600-604 Congress St

Attached are the (REV 2) Arch dwgs revised (A3,A8,A9,A11,A19-with exact same file names) to remove note re:step at door 102.4 on A3, incorporate exterior brick reveal at existing windows (removed), and answers to your 3 questions in July 27 email.

From: Jeanie Bourke <jmb@portlandmaine.gov>
Date: July 27, 2017 at 3:39:01 PM EDT
To: apartmentmart1952@gmail.com
Cc: mainenautical@icloud.com, John H Leasure <jleasure@maine.rr.com>
Subject: 600 Congress St., BP# 2017-00812 plan review comments

BUILDING LOCATED AT
602 CONGRESS STREET
PORTLAND, MAINE
EXTERIOR DECKS
GENERAL NOTES, PLANS AND ELEVATION

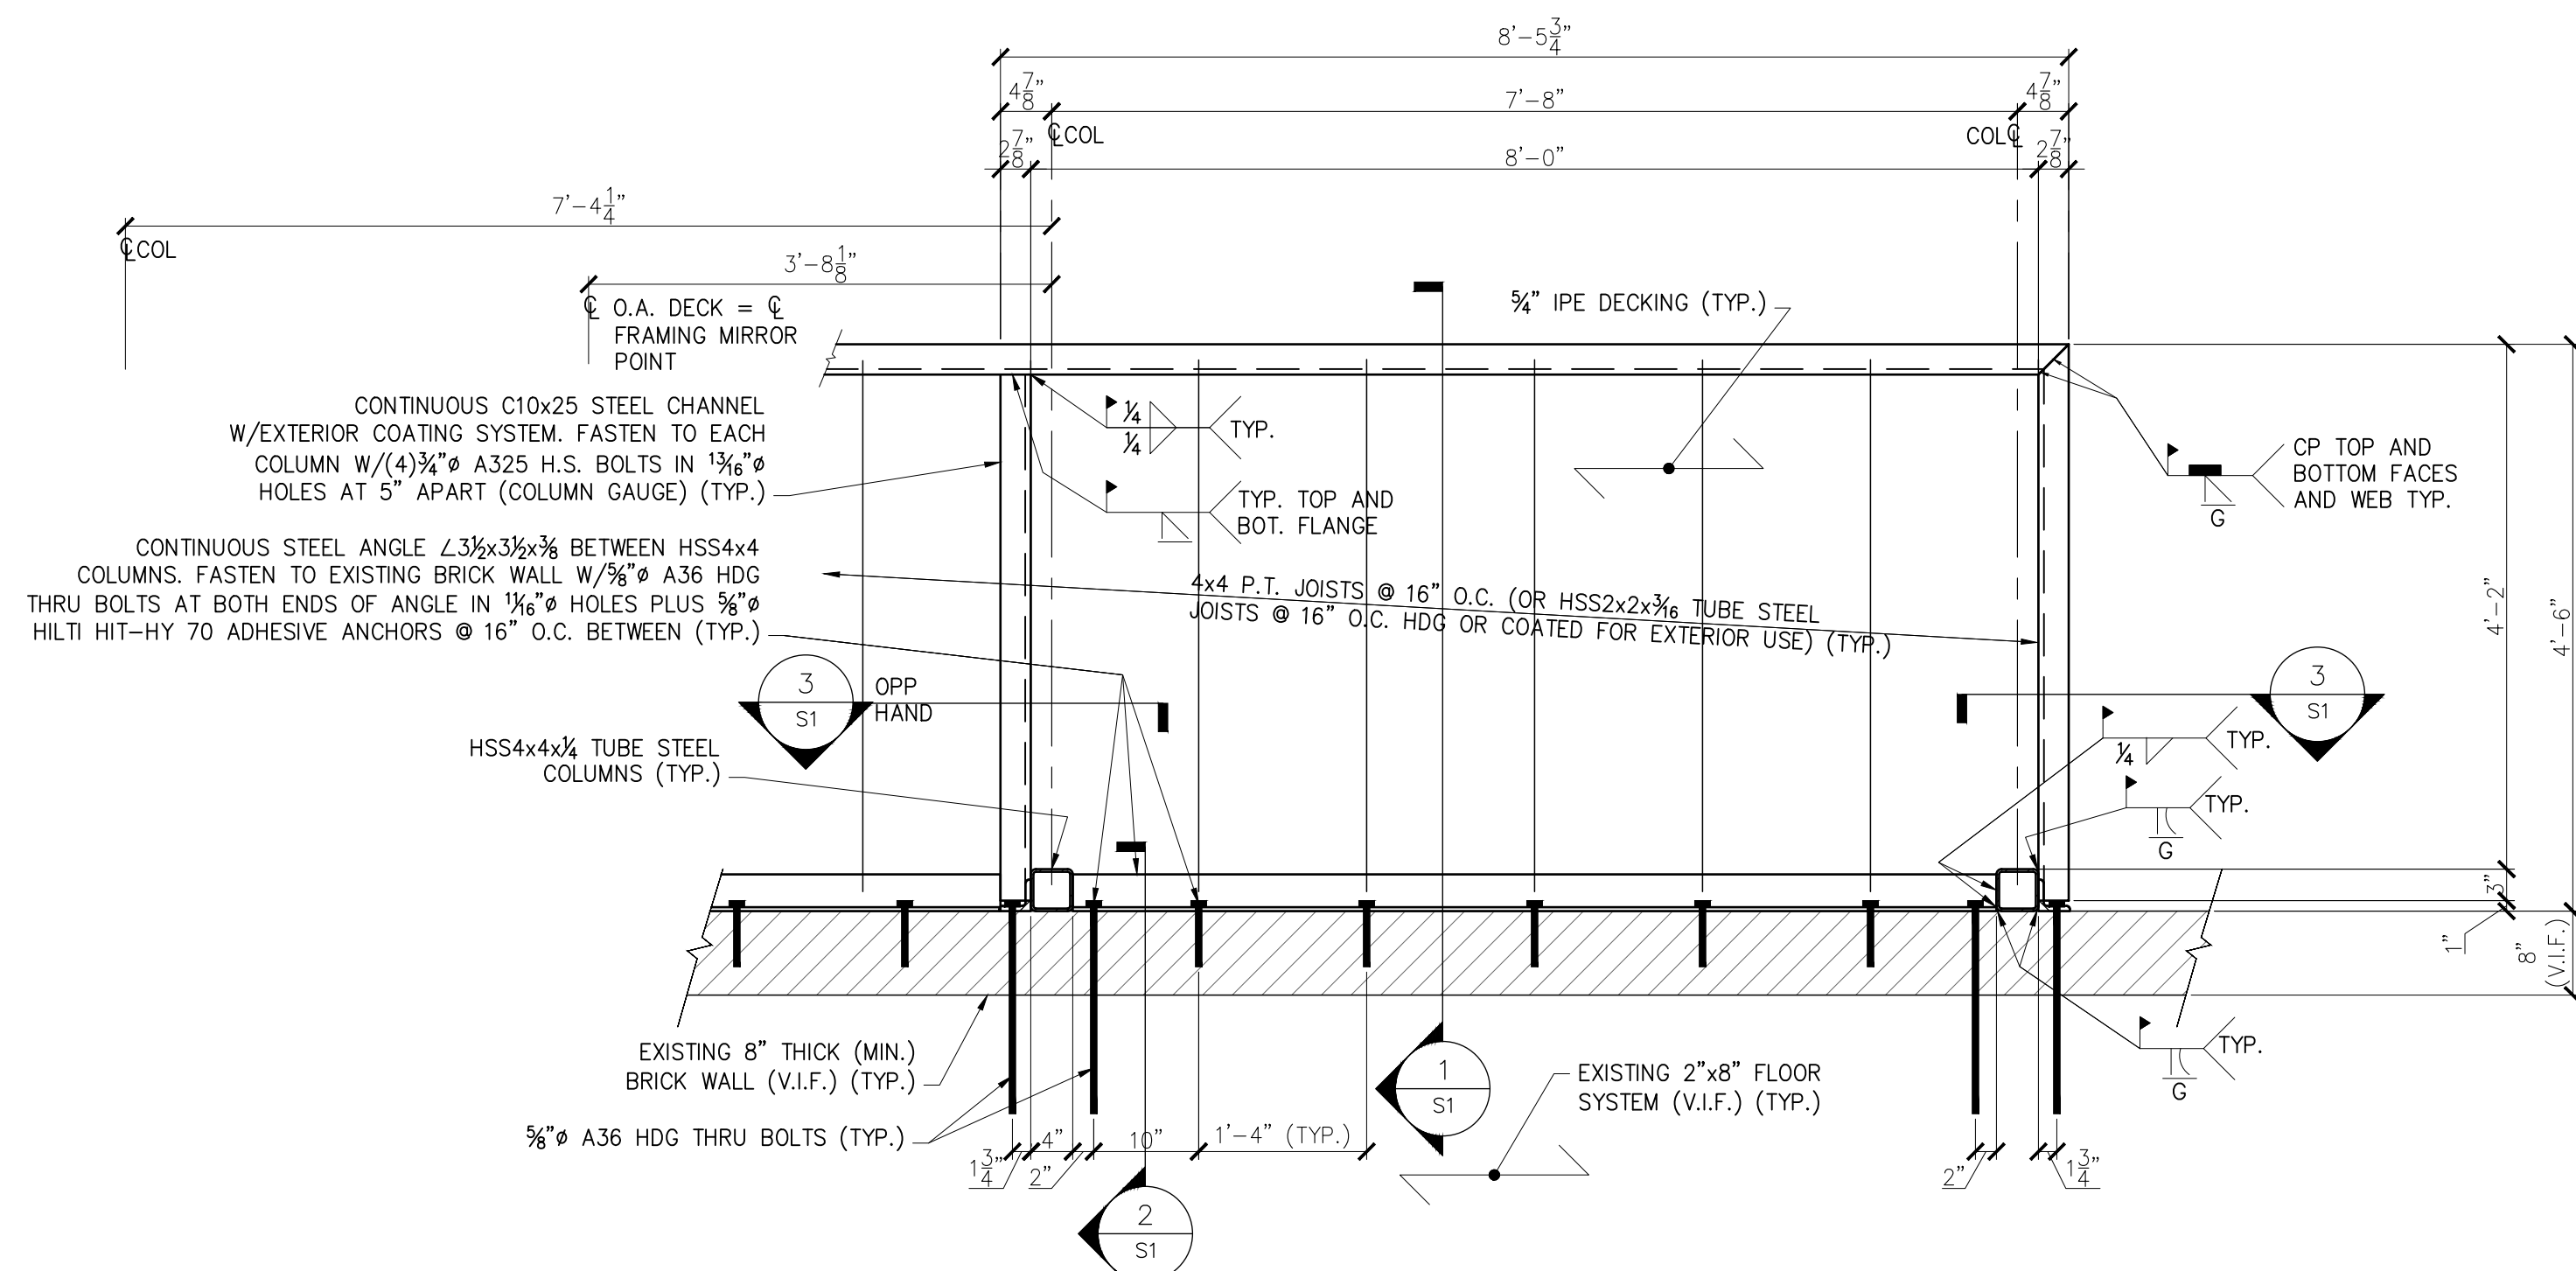
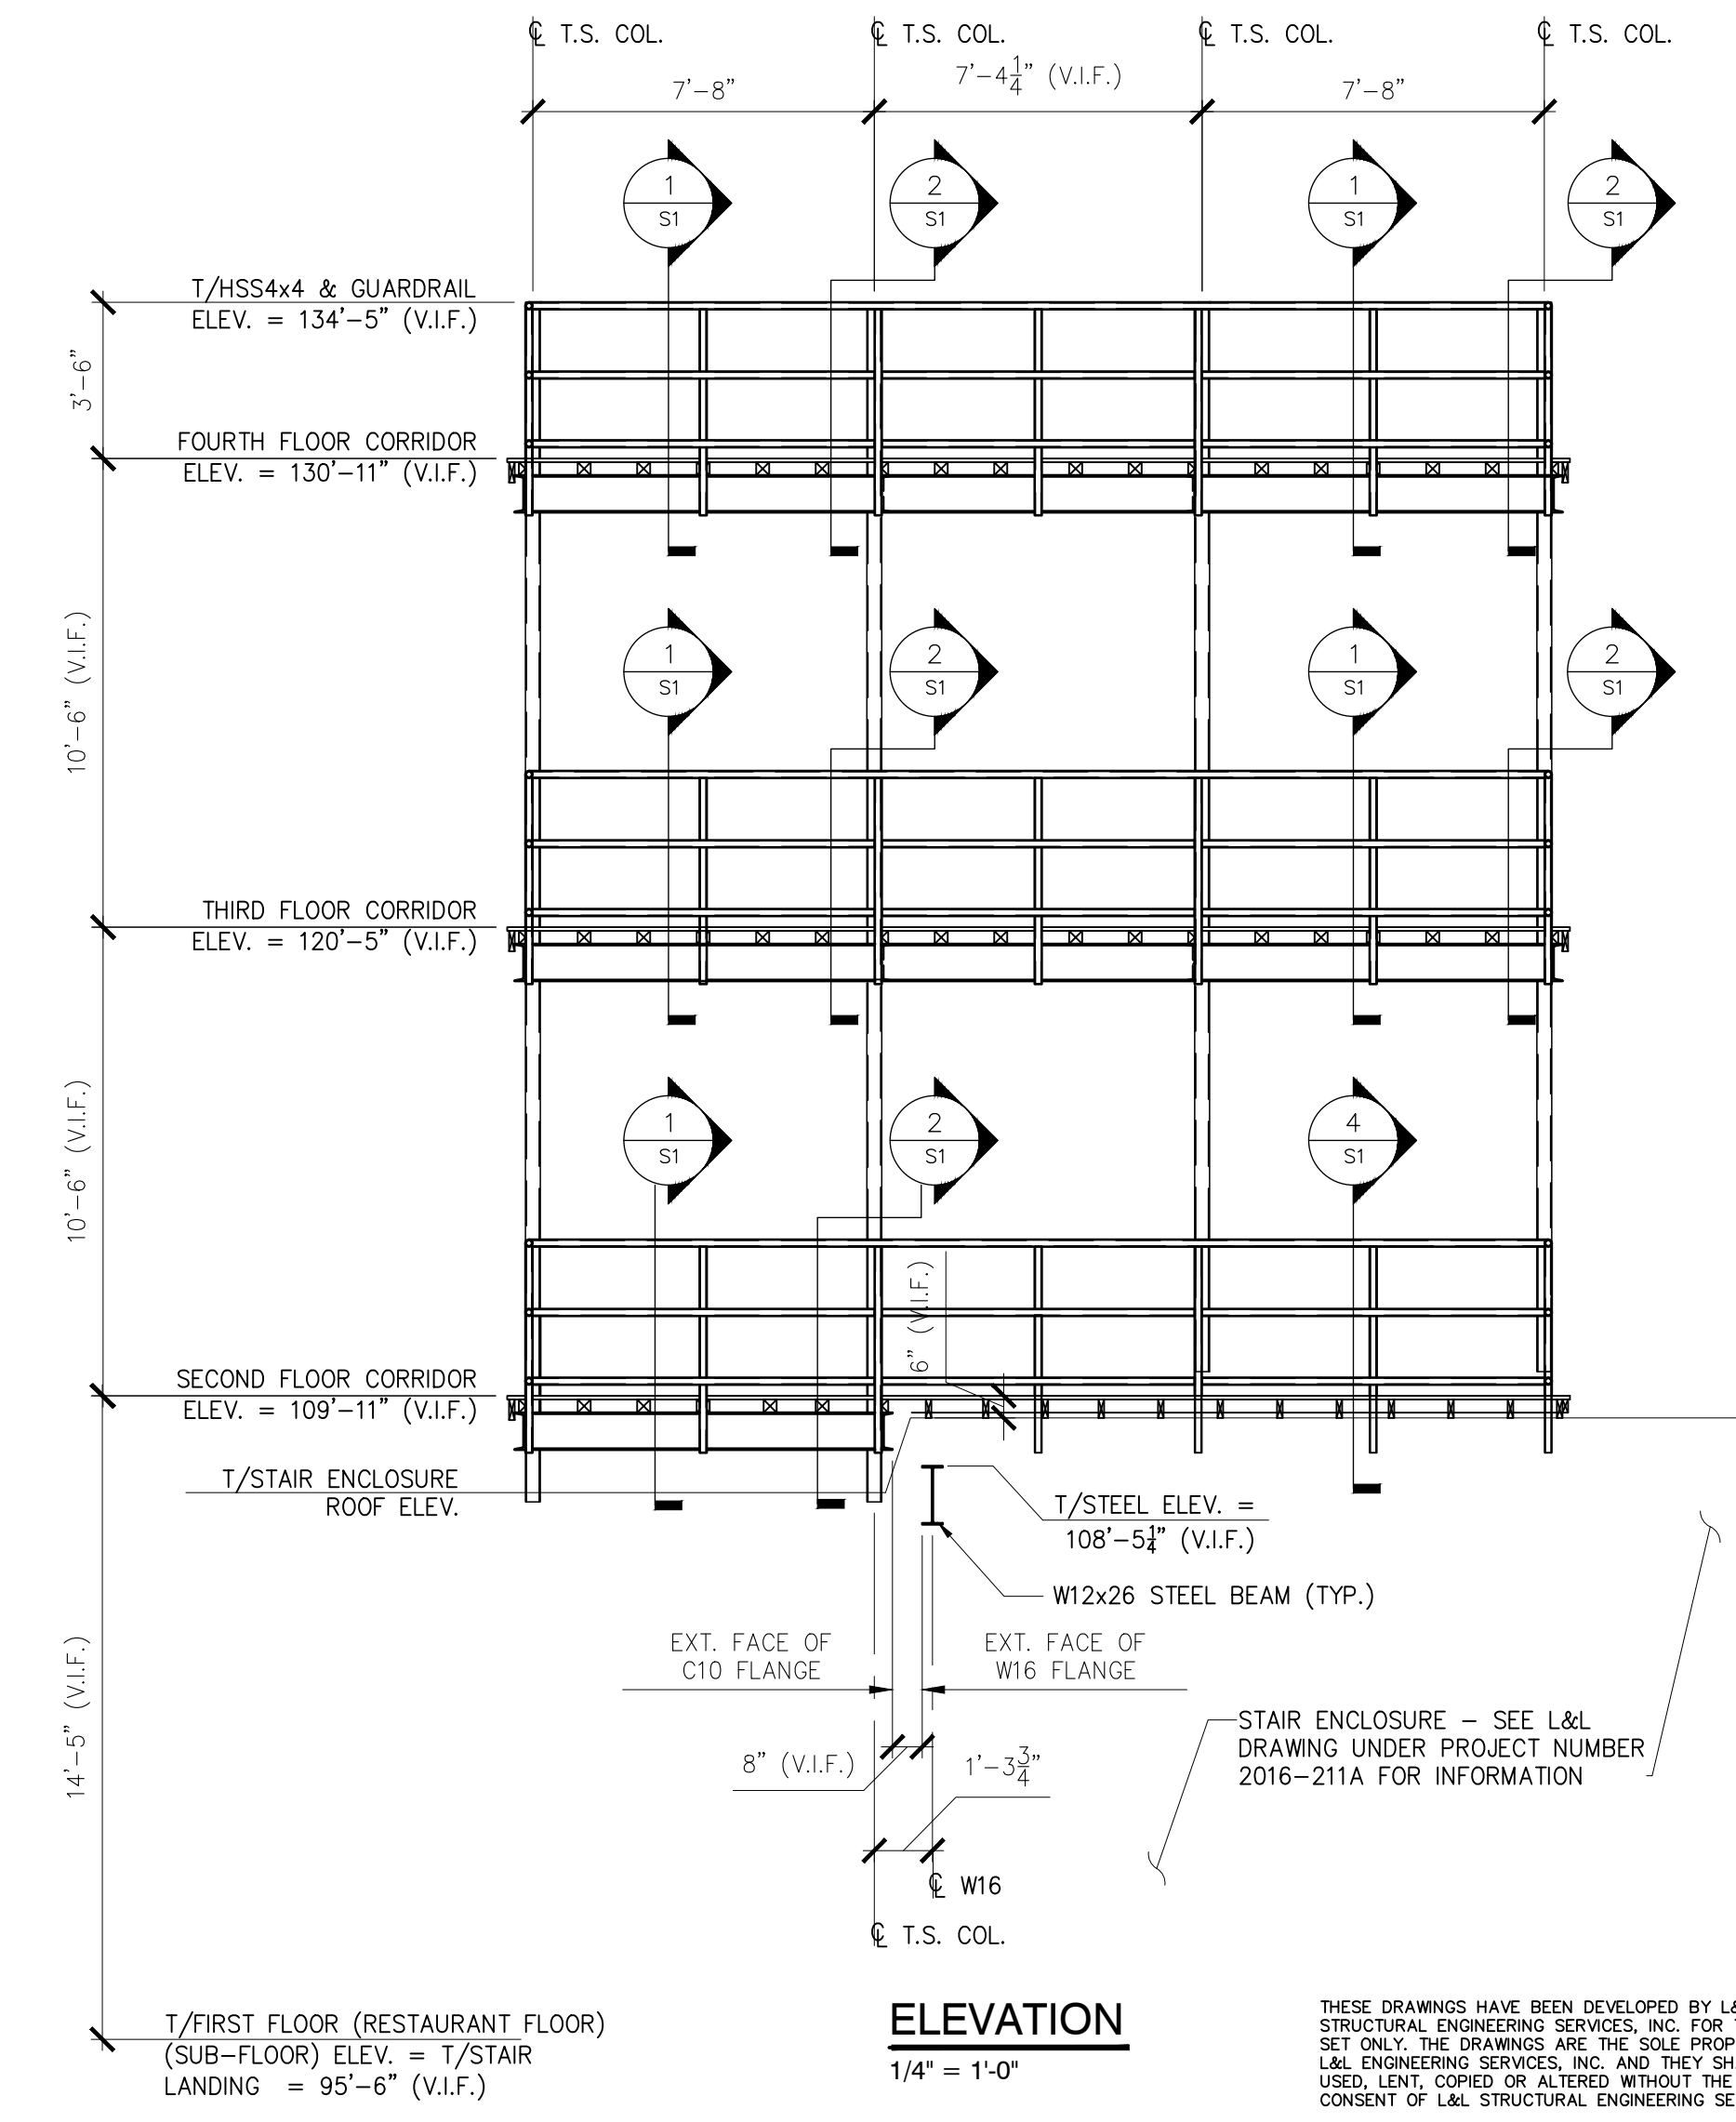
1. Any new or updated structural plans since the date of this application as noted on the project description Section 2.

The structural drawings for the proposed rear entry enclosure and rear elevated exterior decks have been submitted. We are in the process of finalizing the structural drawings for the roof reinforcement/re-support required to enable the roof to support current code stipulated loads in accordance with the building code for existing buildings resulting from the additional insulation that is proposed. In addition, we are in the process of reviewing the existing floor structure within the main building to confirm that the existing floor structure has been constructed in general compliance with the previous contract documents prepared for the building structure by Structural Integrity and L & L Structural Engineering Services. We anticipate that additional structural design and structural drawing preparation will be required to document additional remediation that will be required to address discovered deficiencies as well as structural reinforcements/re-supports that have not been properly constructed in accordance with the previous contract documents.
